Community Development Department
501 Delta Avenue
Marysville, WA 98270

RE: Sunrise Grove Apartments – Technical Review 1
Response to Comment Letter

Please refer to the following in response to the Technical Review 1 comments provided March 13, 2023:

**P1.0**

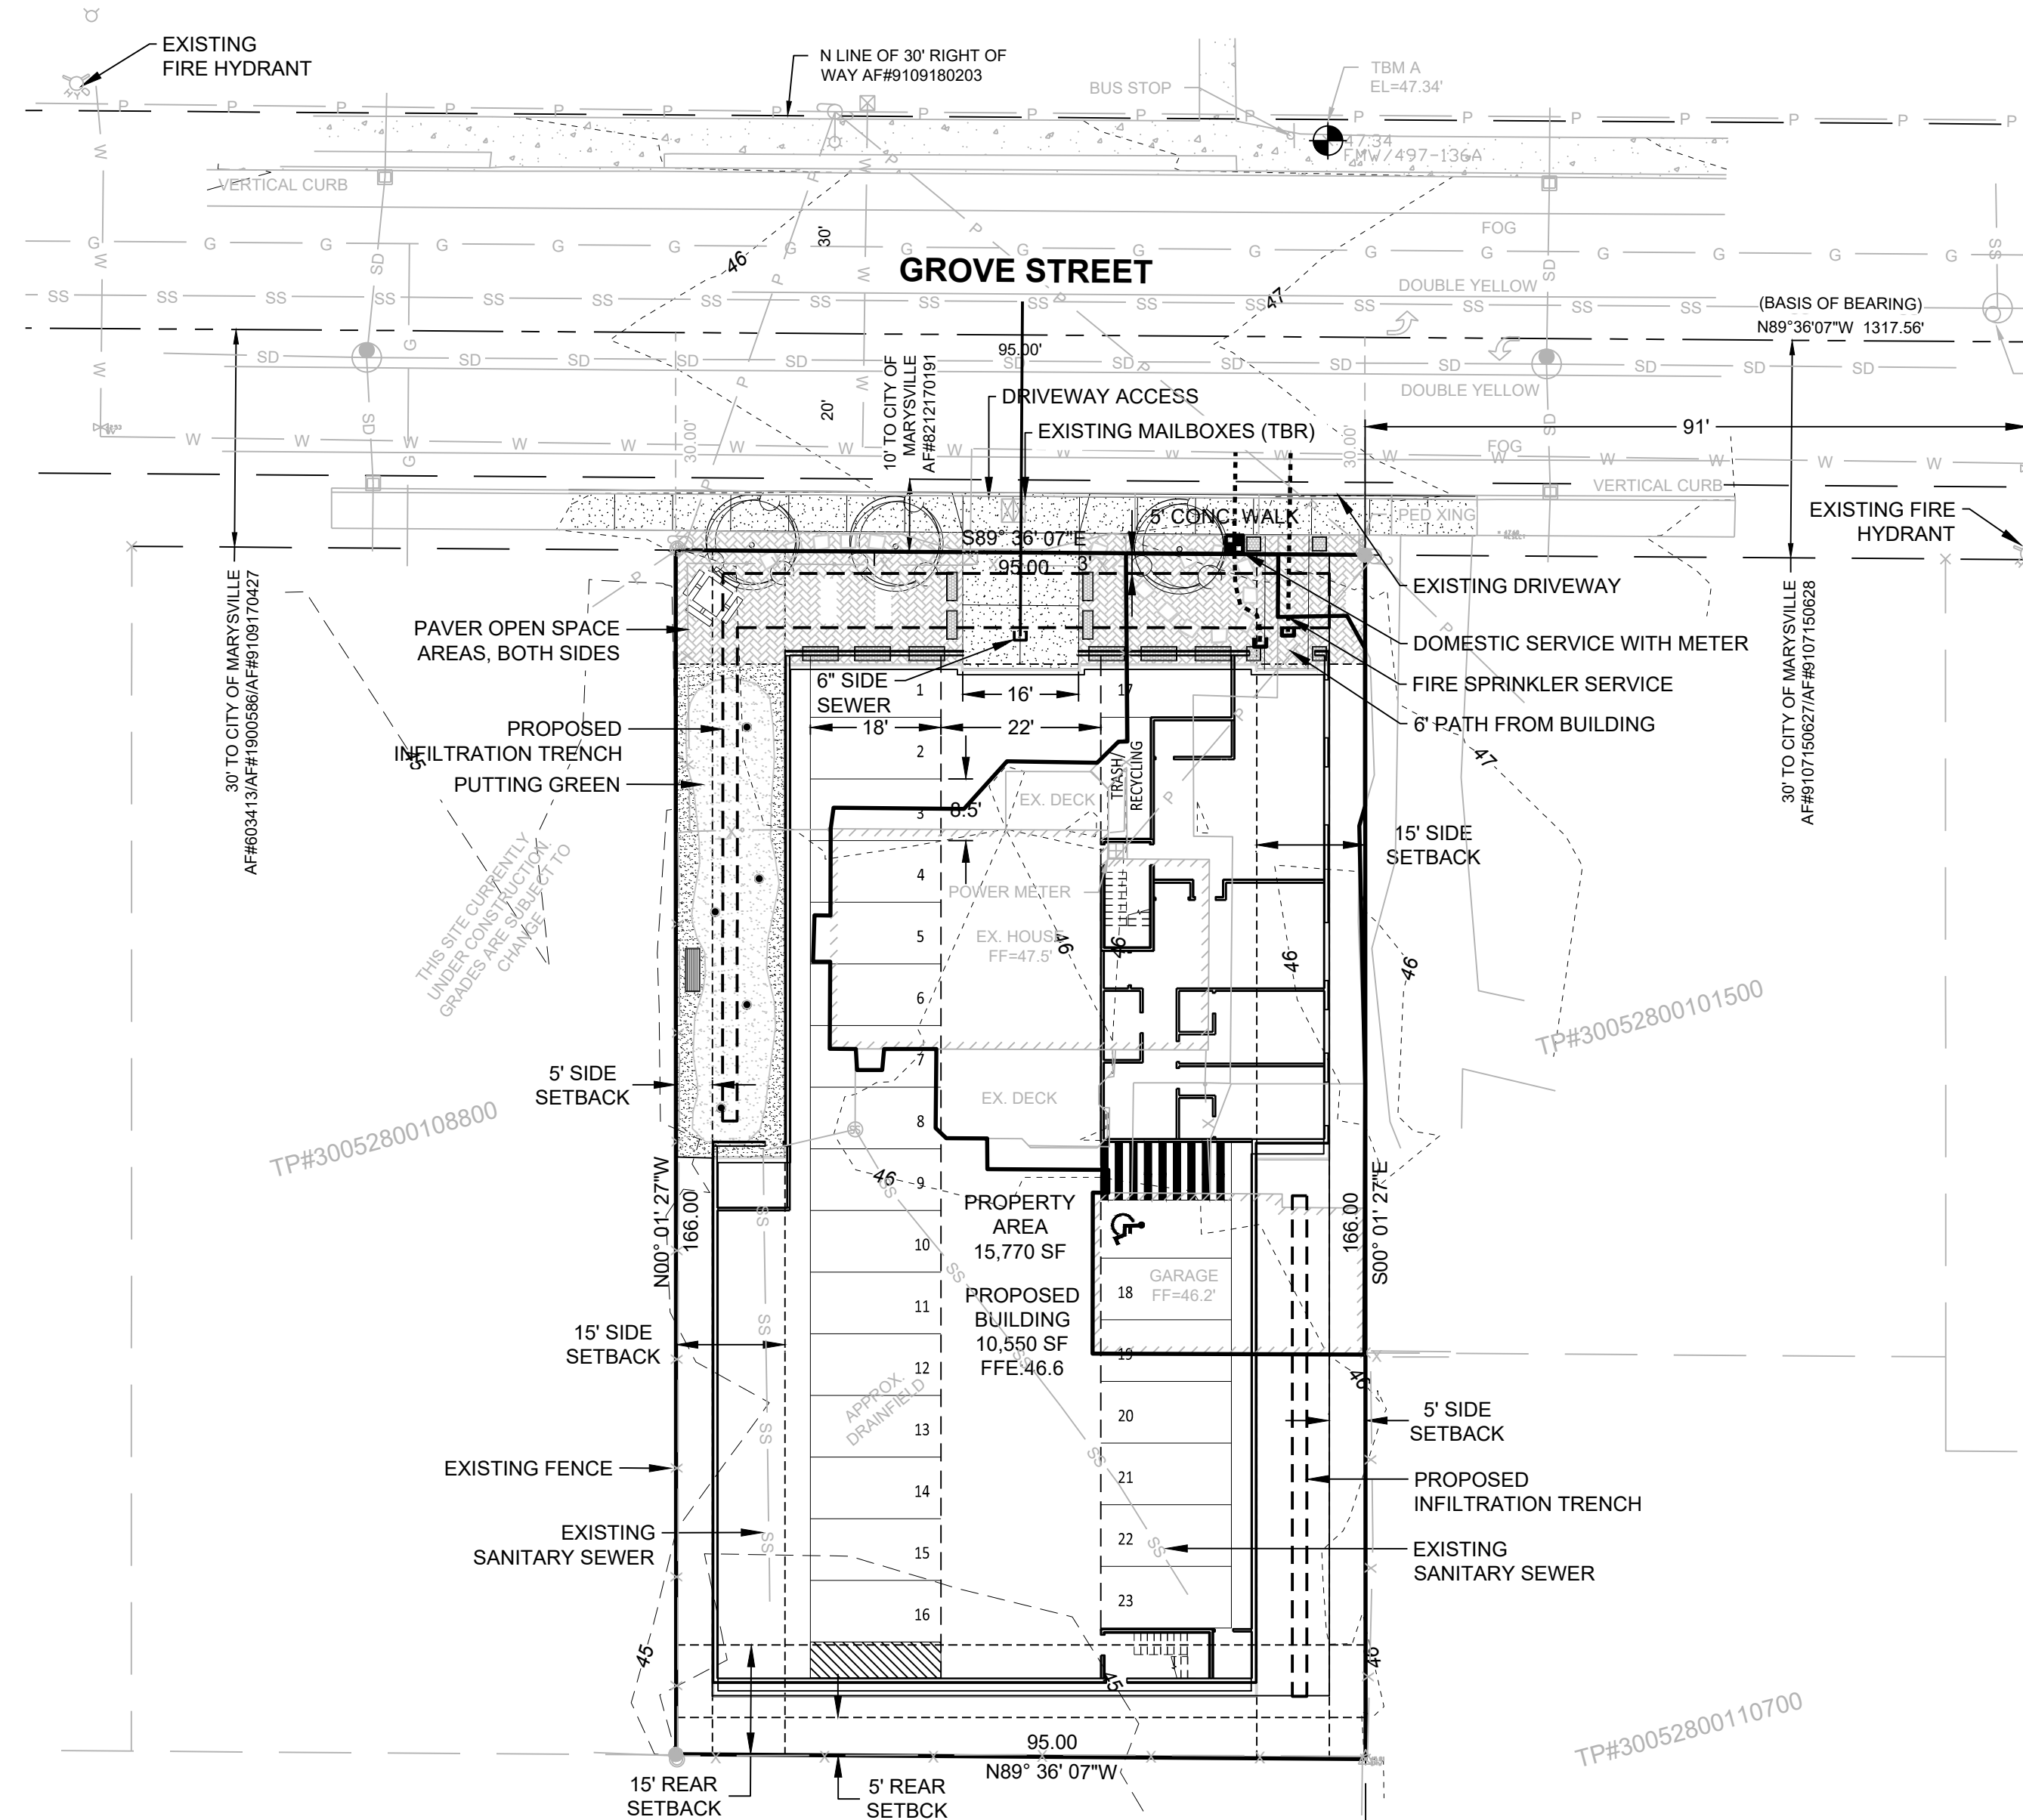
1. "PA23002" has been added to and will remain on all site, civil, landscape and architectural submittals. See title blocks of all sheets.
2. Density calculations, Dimensional Standards, Proposed Density Incentives, and Bicycle Parking Calculations have been added. See Sheet P1.0

3. The site plan has been adjusted/updated to align the landscape with the building footprint, restoring parking stalls 1 and 17 to a standard 8'-6" parking width. See P1.0
